Re: EN 010151 - Beacon Fen Energy Park

Boston Borough Council's - Deadline Six Submission – 12th January 2026.

The letter sets out Boston Borough Council (BBC) response to the Applicants Deadline 5 submissions for the above Project.

Figure 6.31 Landscape Strategy Plan Part 1 (Change Request)

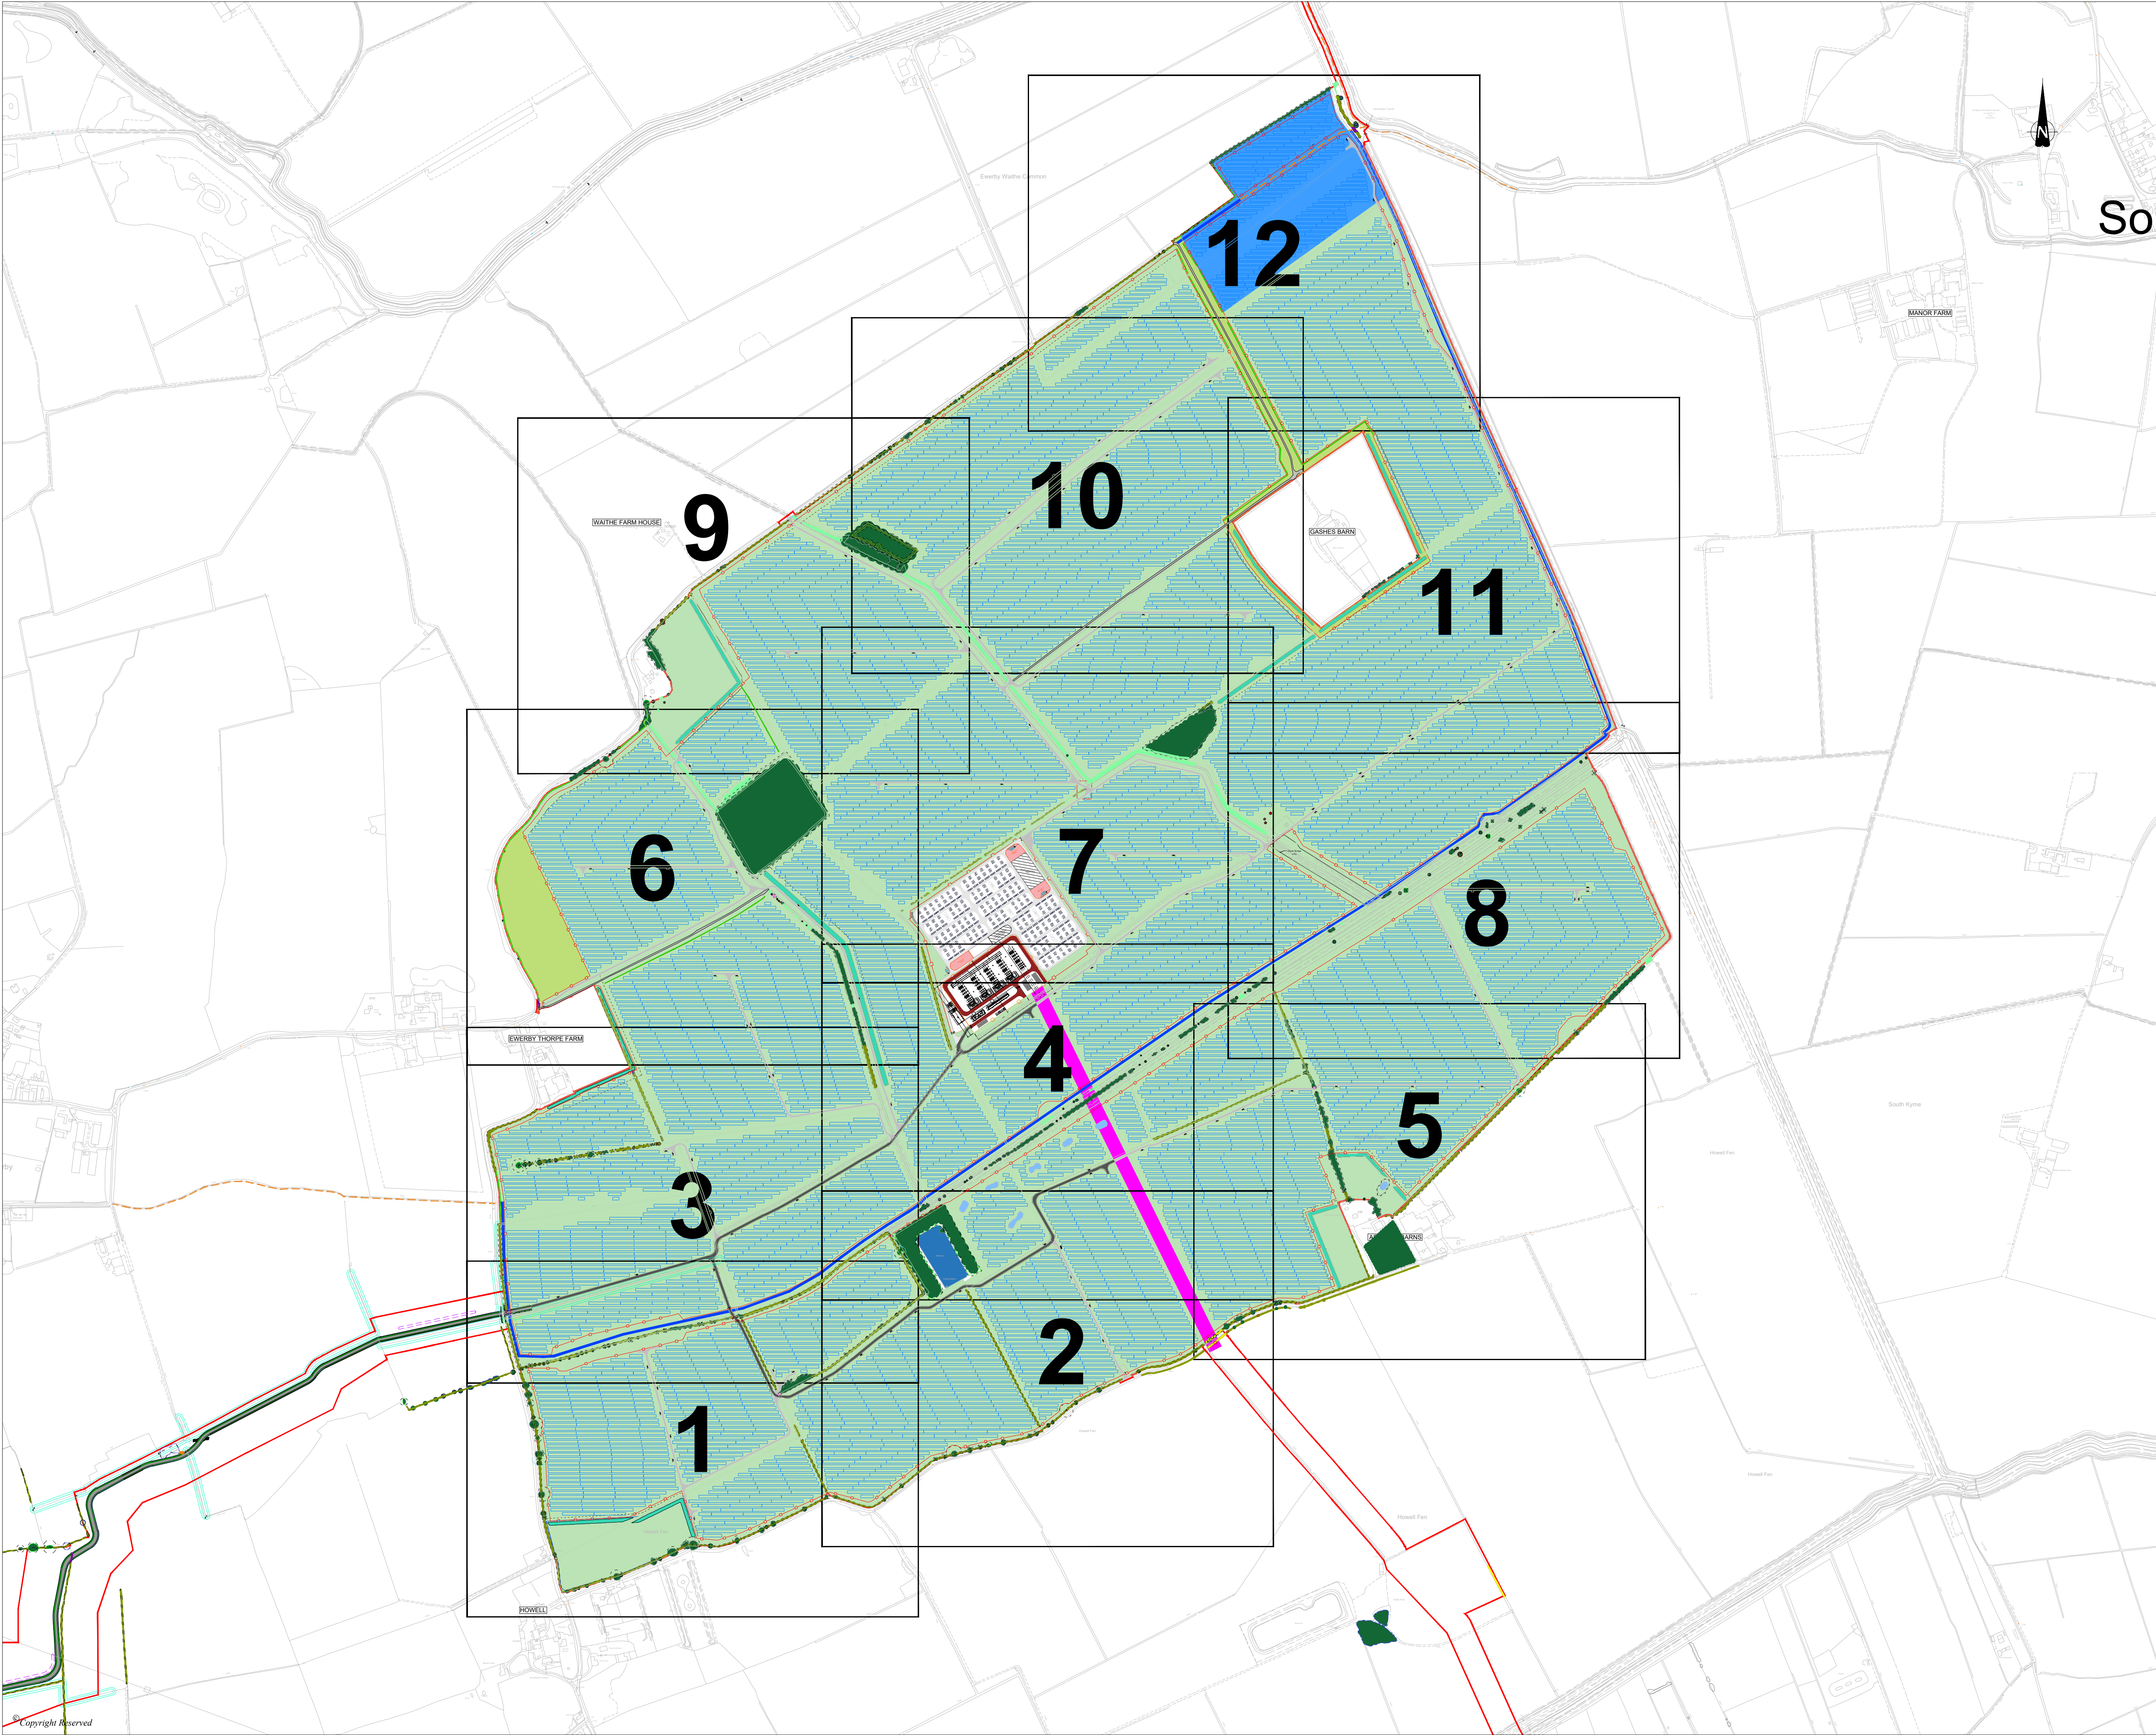
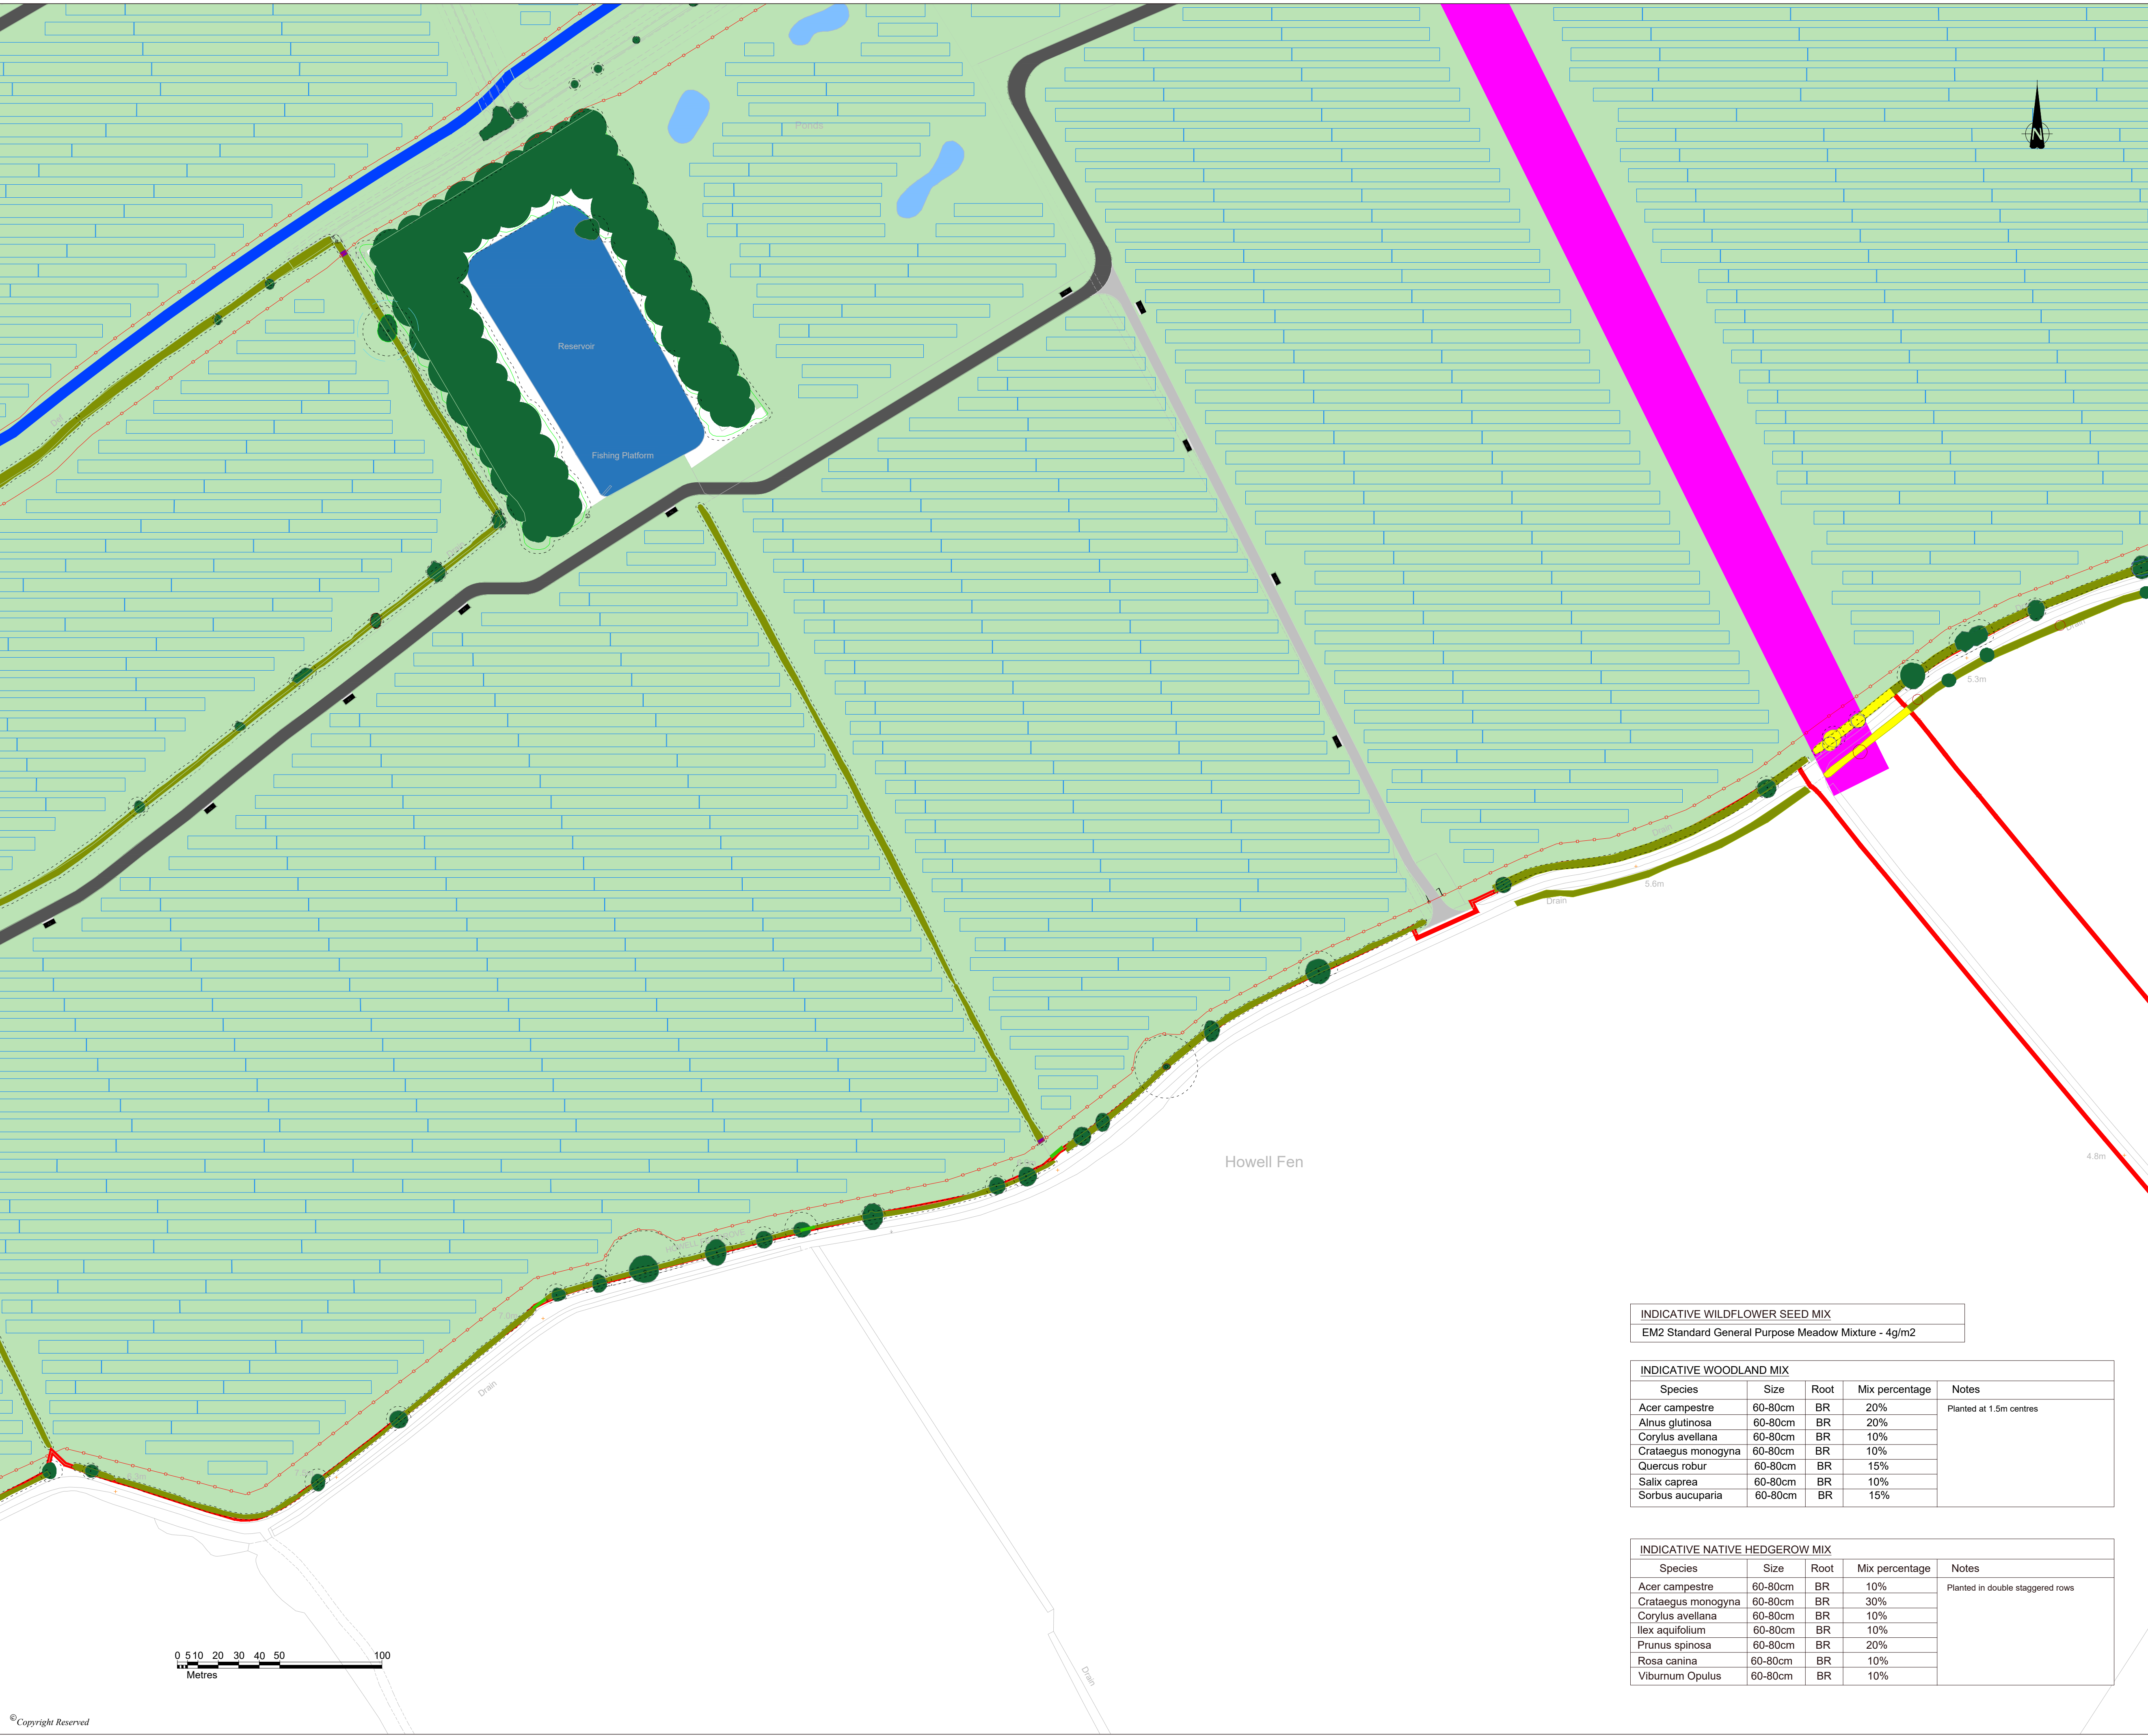
The Landscape Enhancement Measures included within the Change Request OLEMP (CR-016) and Change Request Landscape Strategy Plans (CR-021) at the existing Bicker Fen Substation are not included within the D5 OLEMP (REP5-026). BBC therefore requests that the OLEMP is updated to avoid confusion and understands that the Applicant will submit an updated OLEMP.

The Landscape Strategy Plan also references areas where vegetation is to be temporarily removed or temporarily lain to aggregate and, in both cases, reinstated. There is also reference to a restoration plan.
